The Morecambe Offshore Windfarm Generation Assets

Spirit Energy's Responses to the Applicant's comments on Spirit Energy's Relevant Representation

EN010121
Unique Reference: 20049981

Date	26 November 2024
-------------	------------------

Development Consent Order: Schedule 3 Spirit and Harbour Protective Provisions Plan

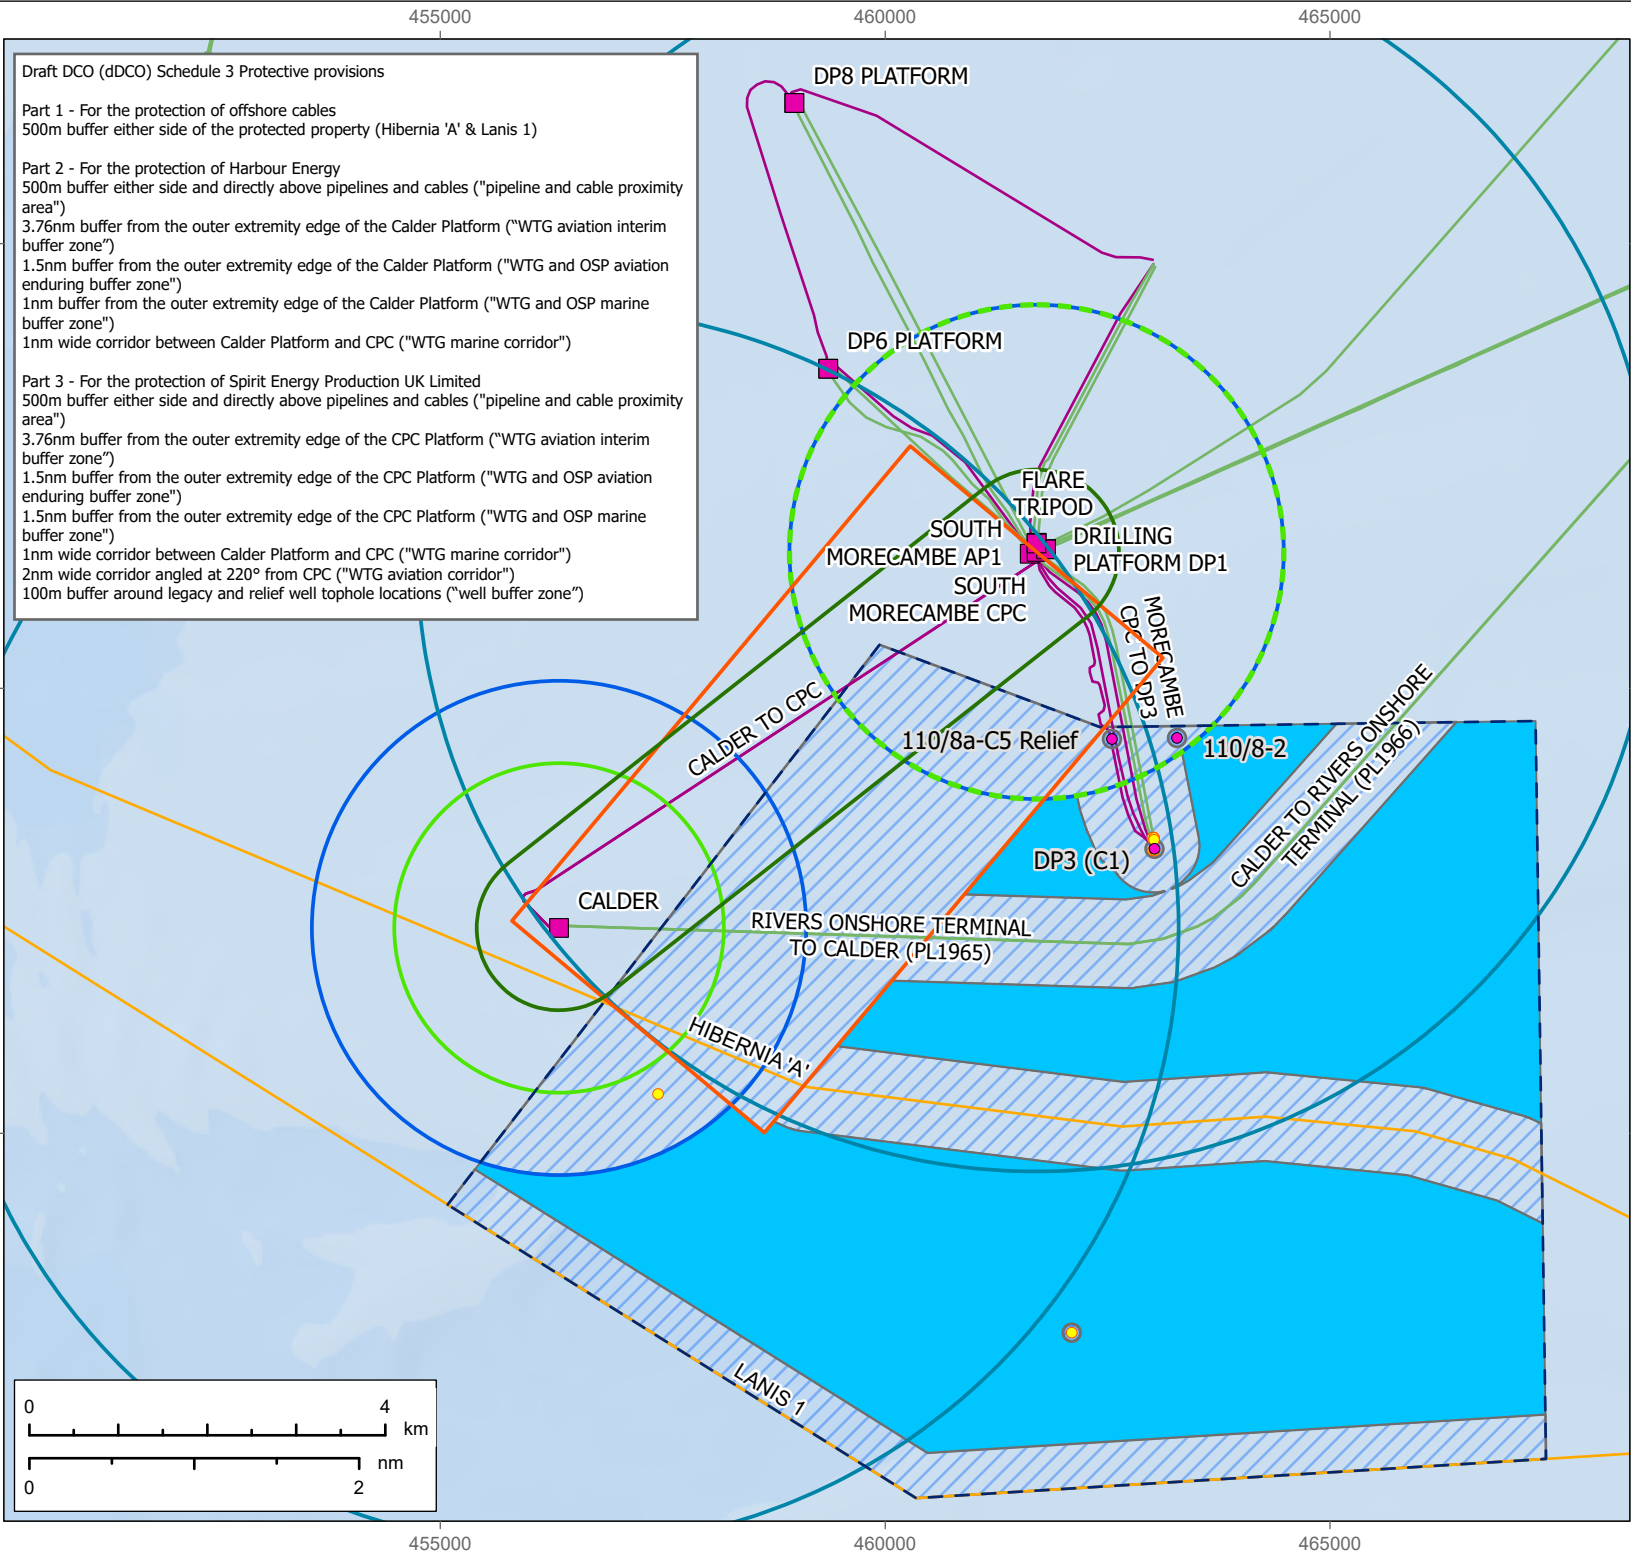
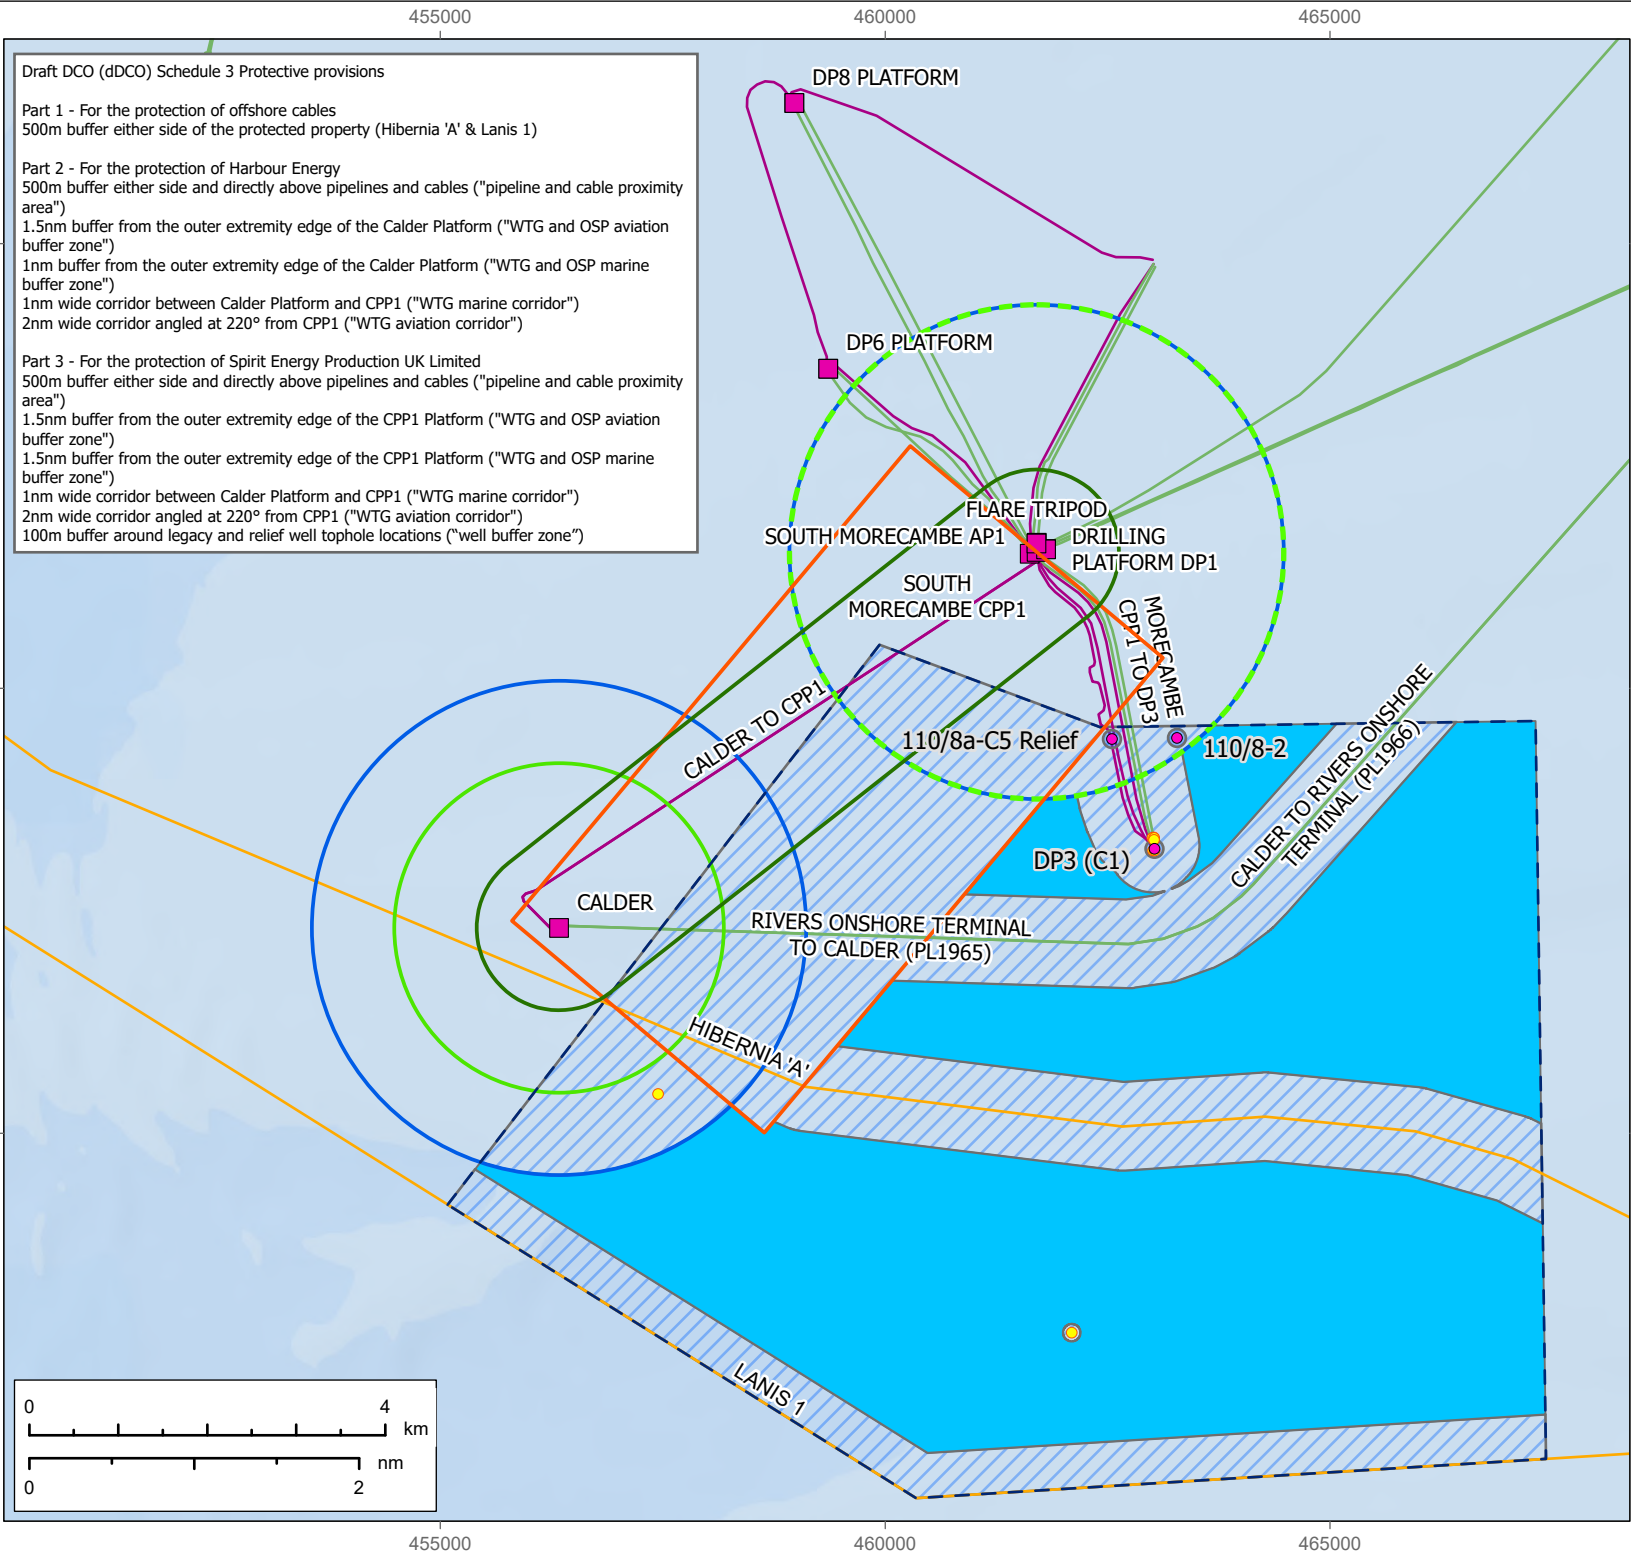
ID	RR	Applicant's Response	Spirit Energy Response to Applicant
RR-077-14	<p>Paragraph 3 (restriction on unauthorised development) of Part 3 of Schedule 3 of the dDCO (Protective provisions for the protection of Spirit Energy) states: <i>“No wind turbine generator or offshore substation platform shall be erected in the pipeline and cable proximity area or in the WTG and OSP buffer zone unless otherwise agreed in writing between the owner and the undertaker.”</i></p> <p>The following terms referred to above are defined at paragraph 2:</p> <p><i>“pipeline and cable proximity area” means the area five hundred meters (500m) either side and directly above the pipeline and cable;”</i></p> <p><i>“WTG and OSP buffer zone” means an area of one point five nautical miles (1.5 nm) of clear airspace measured from the outer extremity edge of each of the AP-1 helideck and DP-1 helideck to any tip from any wind turbine generator located within the Licence and extending vertically from mean sea level.”</i></p> <p>It is the latter definition that is particularly important. Specifically, that the 1.5nm “buffer zone” used in the ES is secured by virtue of the protective provisions applying a 1.5nm minimum separation distance between turbine tips measured from (only) the following:</p> <ul style="list-style-type: none"> ▪ The AP-1 helideck – defined paragraph 2 	The Applicant notes this response.	N/A

ID	RR	Applicant's Response	Spirit Energy Response to Applicant
	<p><i>platform located in the United Kingdom Continental Shelf Block 110/7a"</i></p> <p>Any references to a 1.5nm "buffer zone" in this representation must be considered by reference to the aforementioned protective provisions and definitions.</p>		
RR-077-15	<p>As an important preliminary matter, Spirit note that the protective provisions for its benefit are framed in a way that only secures the 1.5nm buffer zone for aviation purposes – this separation distance being measured from the AP-1 helipad and DP-1 helipad. The consequence is that the removal of those helipads in turn removes the 1.5nm buffer zone. That being the case:</p> <ul style="list-style-type: none"> ▪ The protective provisions effectively only secure a 500m buffer zone for shipping and navigation purposes. For reasons that we come onto at Part 6 that is inadequate, especially as marine requirements will remain to enable Spirit to manage decommissioning obligations and secure rig and heavy lift vehicle access until mid-2030's. For the foregoing reason, and to aid clarity, Spirit's position is that the protective provision must be split out and articulated separately for marine and aviation requirements. <p>The protective provisions do not contemplate any change to the helipad locations at the Central Processing Complex or a new location for the take-off and landing of helicopters to serve</p>	<p>The Applicant notes this response. The Applicant will continue to engage with Spirit Energy to ensure that the definition of the buffer zones within the protective provisions (Schedule 3 Part 3 of the draft DCO APP-012) is appropriate for Spirit Energy's operations.</p> <p>As set out in at RR-077-88 below, the Applicant proposes to include revised protective provisions in the version of the draft DCO submitted at Deadline 2.</p>

ID	RR	Applicant's Response	Spirit Energy Response to Applicant
	<p>the Central Processing Complex infrastructure. Thus the 1.5nm simply assumes the "status quo". That is plainly inadequate: the buffer zone (which for the reasons we come onto must be a greater distance than 1.5nm in any event) must be measured, as we note is the case with the protective provision in respect of Calder, from the "outer extremity" of all of the Central Processing Complex infrastructure.</p>		
Part 4 – Legislative and policy context			
RR-077-16	<p>We generally agree with the statement of legislation and policy set out in chapter 2 of the ES. However, the following section is of particular relevance to consideration of the Application in light of Spirit's interests and operations in the area.</p> <p>The oil and gas sector is highly regulated. The impacts of the Project on Spirit's existing and future operations will require to be managed by Spirit in the context of that regulatory framework. Accordingly, the implications of applicable regulatory frameworks (as set out in the paragraphs that follow) are relevant to the determination of the Application. As discussed in the remainder of this representation, the EIA undertaken by the Applicant does not fully capture the impacts of the Project in relation to Spirit's interests. Moreover, the health and safety regulatory regime under which Spirit operates requires it to assess the risks arising</p>	<p>The Applicant notes this response.</p> <p>Please refer to the Applicant's subsequent responses on these matters under Parts 4, 5, 6 and 7 of this Spirit Energy Relevant Representation (RR).</p>
